Planning & Urban Development Department

August 7, 2014

RE: 89 Pleasant Avenue, Peaks Island – 087-A-003 (the "Property") – IR-1 Zone with a Shoreland Overlay

I am in receipt of your submitted remediation site plan. Although you have addressed a portion of what was requested, you have not addressed all the Shoreland Zone requirements outlined in my previous letter (attached.)

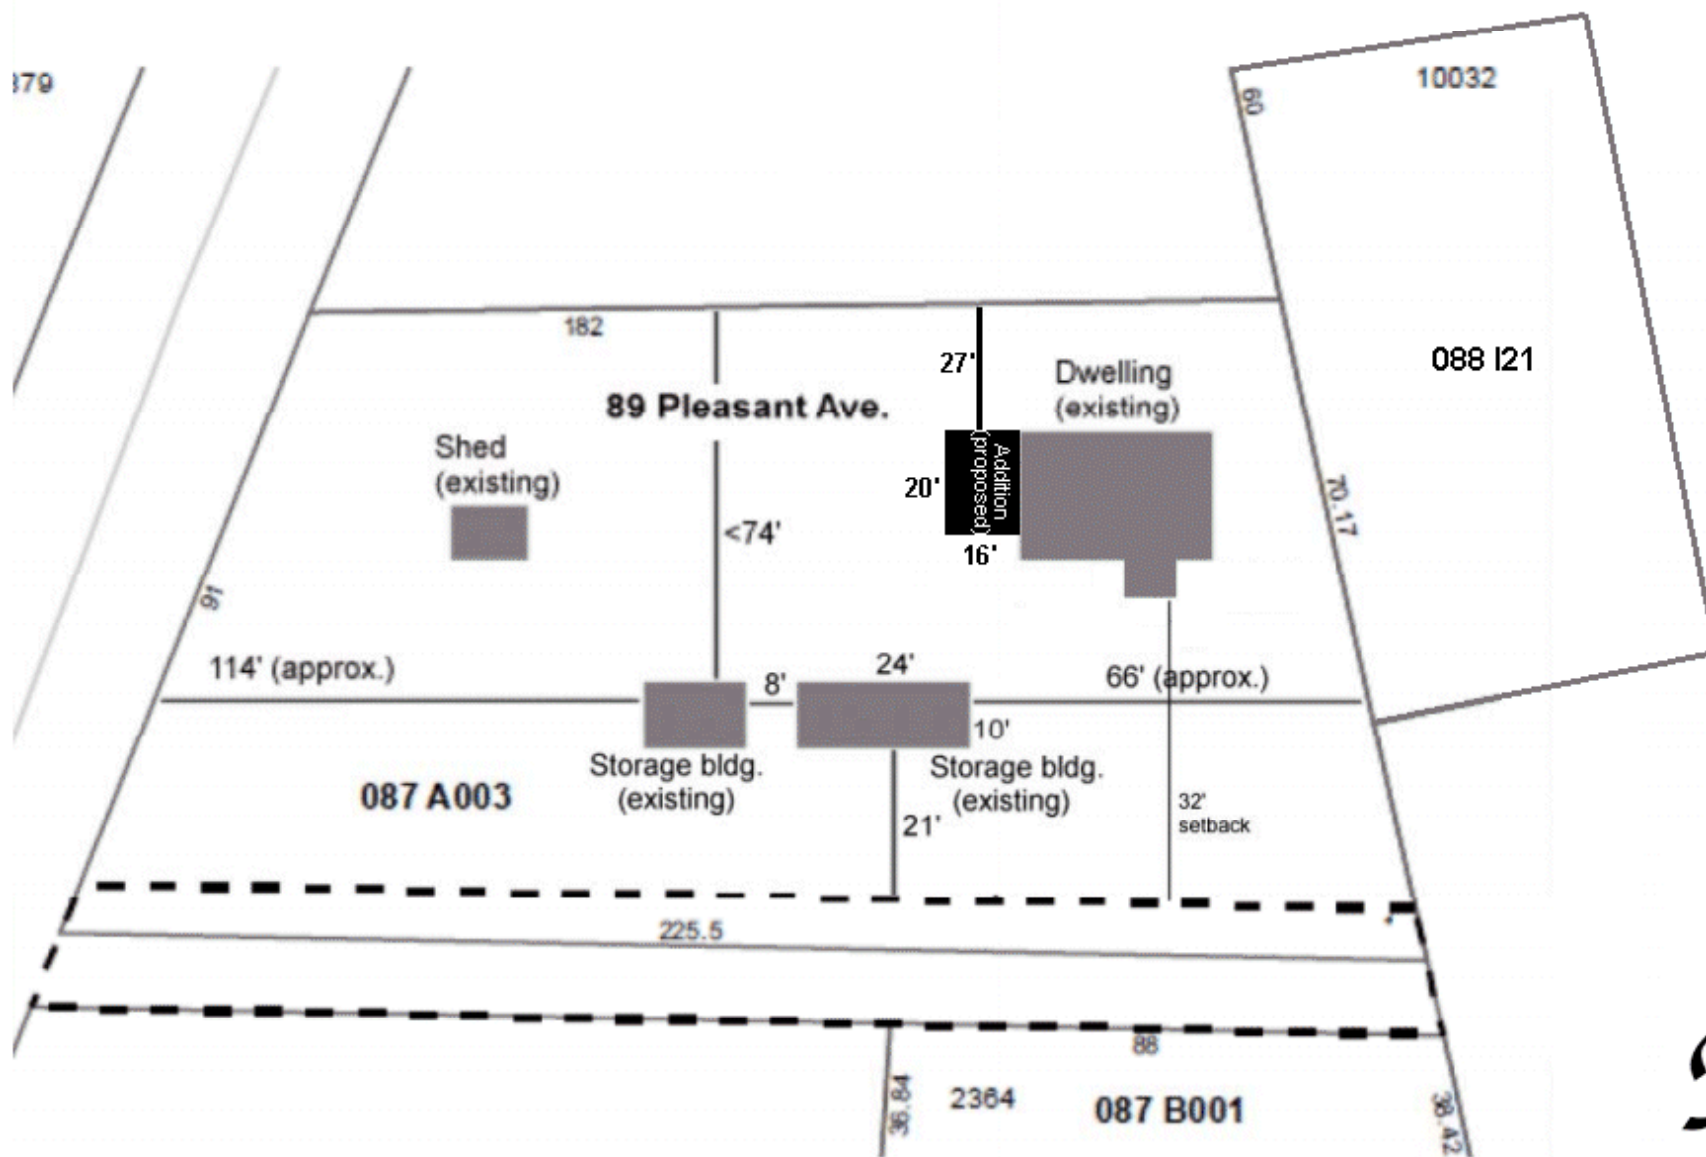
While the planting of eight trees is welcome, your plan does not appear to propose replacement of removed ground vegetation. You will need to replace ground vegetation that was removed with shoreland tolerant vegetation. It would be best to submit a stamped survey indicating all site features, showing previous conditions and the areas where vegetation was previously located to compare with replacement vegetation.
